26 June 2025

TfNSW reference: REN25/00093/004

SSD-9619-Mod-1, Tilbuster Solar Farm; Response to Mod 1 Development Footprint Update Response to Submissions

Transport for NSW (TfNSW) is responding to Tilbuster Solar Farm Mod 1 Response to Submissions, dated 22 May 2025 referred via the Major Projects Portal.

Figure 2: Proposed Route Port of Newcastle to Site

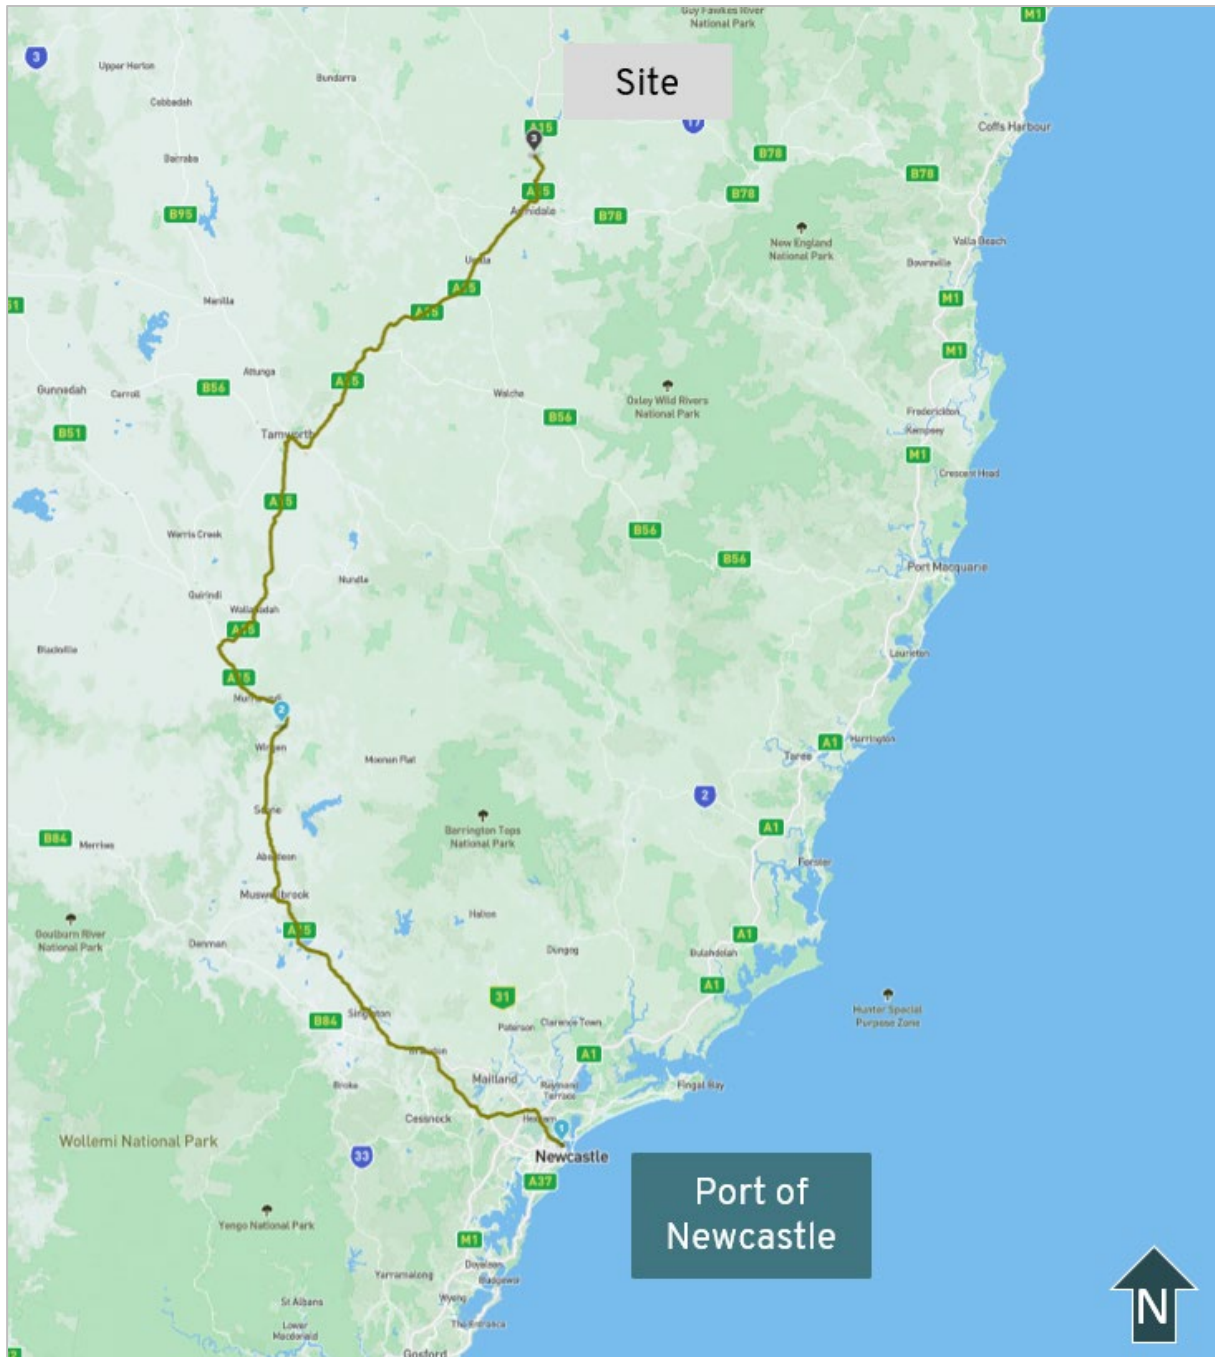
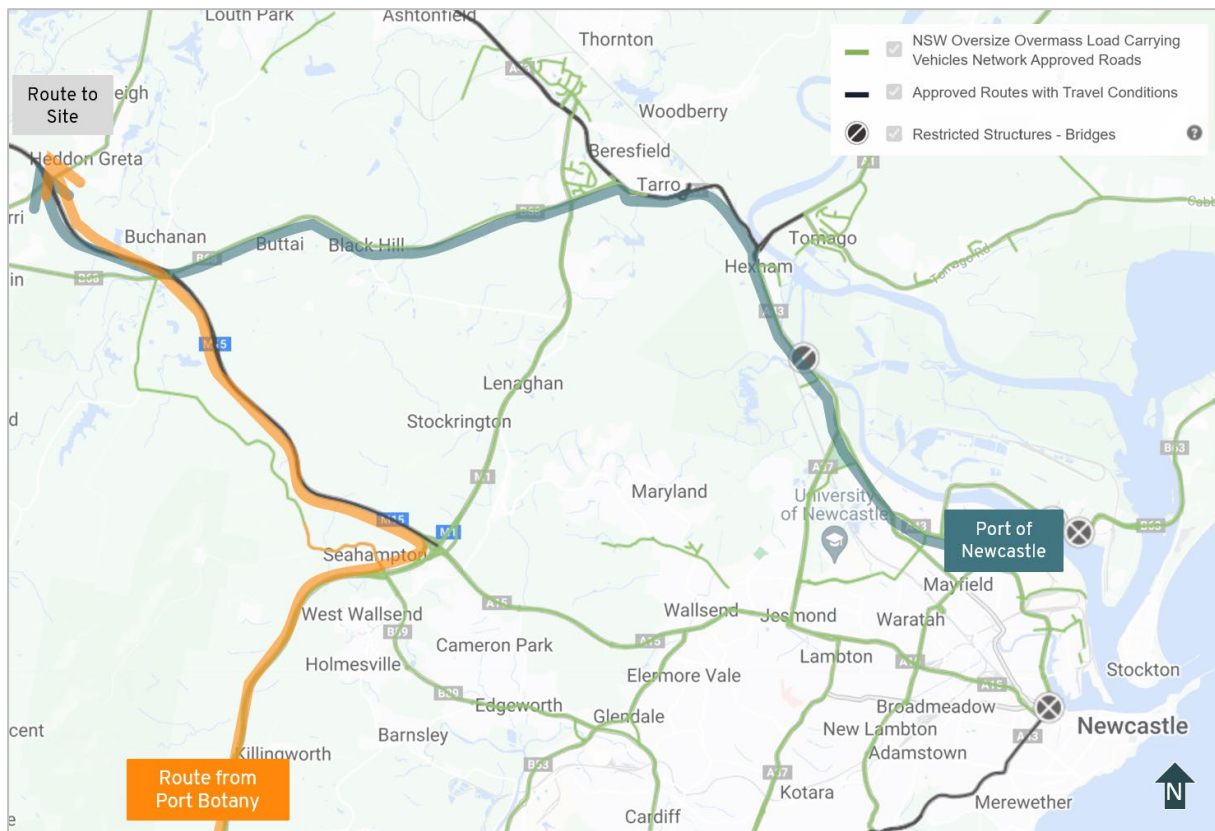
4.	Port of Newcastle haulage route origin TfNSW have no concern with the addition of the Port of Newcastle as an origin destination for the haulage route for all oversize/overmass vehicles (OSOM), if evidence is provided to TfNSW that all OSOM with the laden dimensions and weights (load plus vehicle combinations) conform with the restrictions and limitations identified within the NHVR NSW Class 1 Load Carrying Vehicle Operator’s Guide. If the laden dimensions of the OSOM do not conform with the NHVR NSW Class 1 Load Carrying Vehicle Operator’s Guide and if one of the dimensions or weights fall for the OSOM are classed as high risk OSOM (as defined by the TfNSW website), then a concept route analysis will be required to be provided to TfNSW for review as a part of the response to submissions.	Open: TfNSW requires a concept level route assessment for the movement of the heavy vehicle requiring escort along the Port of Newcastle route. This route assessment is to include the swept path assessments mentioned in the Submissions Report, as well as the information requested in Attachment 2.

- m. The Hexham Straight is a notable project impacting Route 2. The route assessment must assess the alternative route via Newcastle Inner City Bypass to Newcastle Road for high-risk OSOM loads that do not exceed the vertical clearance limitations of 5.25m.
- n. Where the EnergyCo P2R road upgrades are relied on to facilitate the project's high-risk OSOM movements, the pavement extents, scope of work, and bridge assessments for the P2R project are to be reviewed and assessed concerning the project's proposed high-risk OSOM vehicle configuration and loads, to confirm that the loads will be able to move within the design envelope that this project will deliver. Evidence of the consistency check with the EnergyCo P2R project is to form part of the high-risk route assessment.

APPENDIX 5: ROAD UPGRADES AND SITE ACCESS

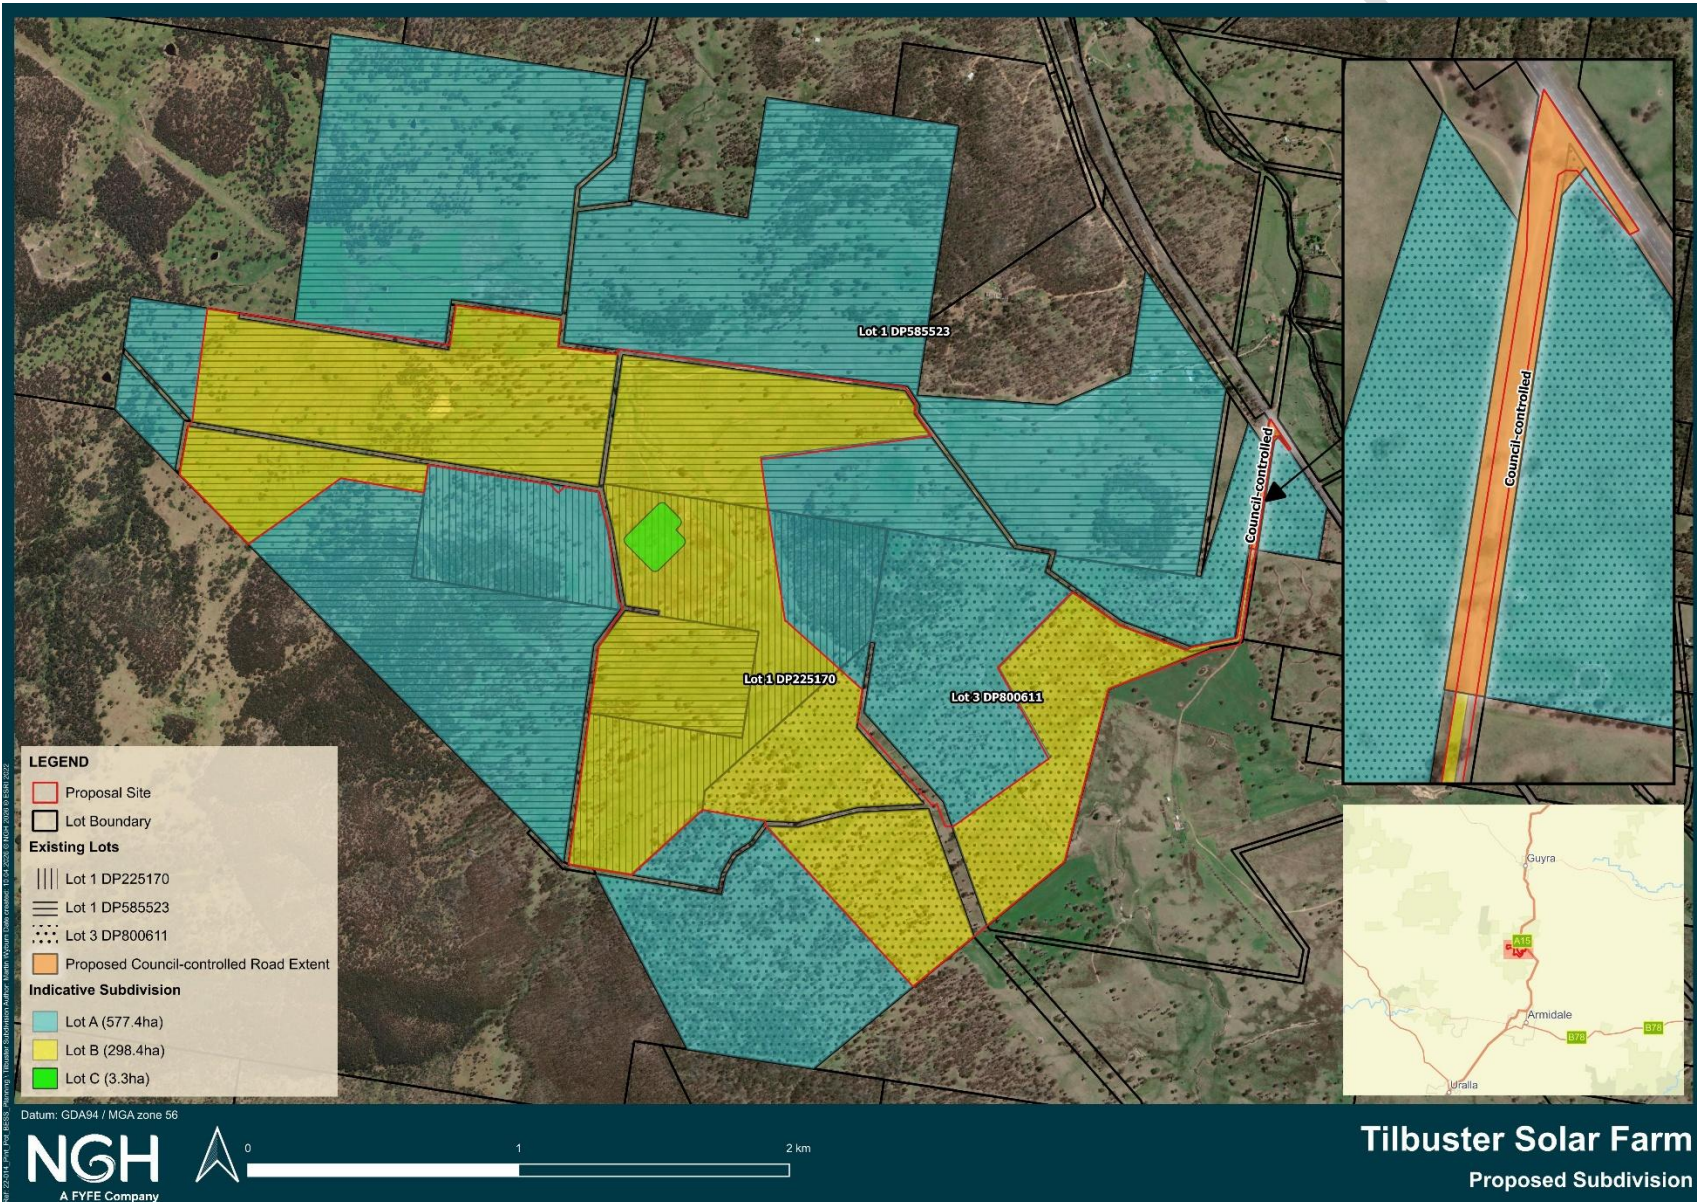
No.	TfNSW comments from Modification 1	TfNSW response to RTS
1.	Development Footprint Expansion TfNSW notes that the development footprint expansion will include access road widening and realignment to the relocated substation. Clarification is sought on where this increased construction footprint is and whether this will have any direct impacts on the New England Highway or road reserve. Noting that any changes to the width must not be contradictory to the approved strategic designs in Appendix 5 for the BAR/BAL and to Condition B5(b) of the Notice of Determination (NoD) dated 3 March 2022, which limits the sealed carriageway to 6.0m and 0.75m (unsealed) shoulders on both sides of the New England Highway.	Closed: TfNSW has no objections to the development footprint expansion, with the understanding that no changes are to be made near the New England Highway with the exception of the intersection treatment in accordance with Condition B4, B5 and Appendix 5 for the Development Consent.
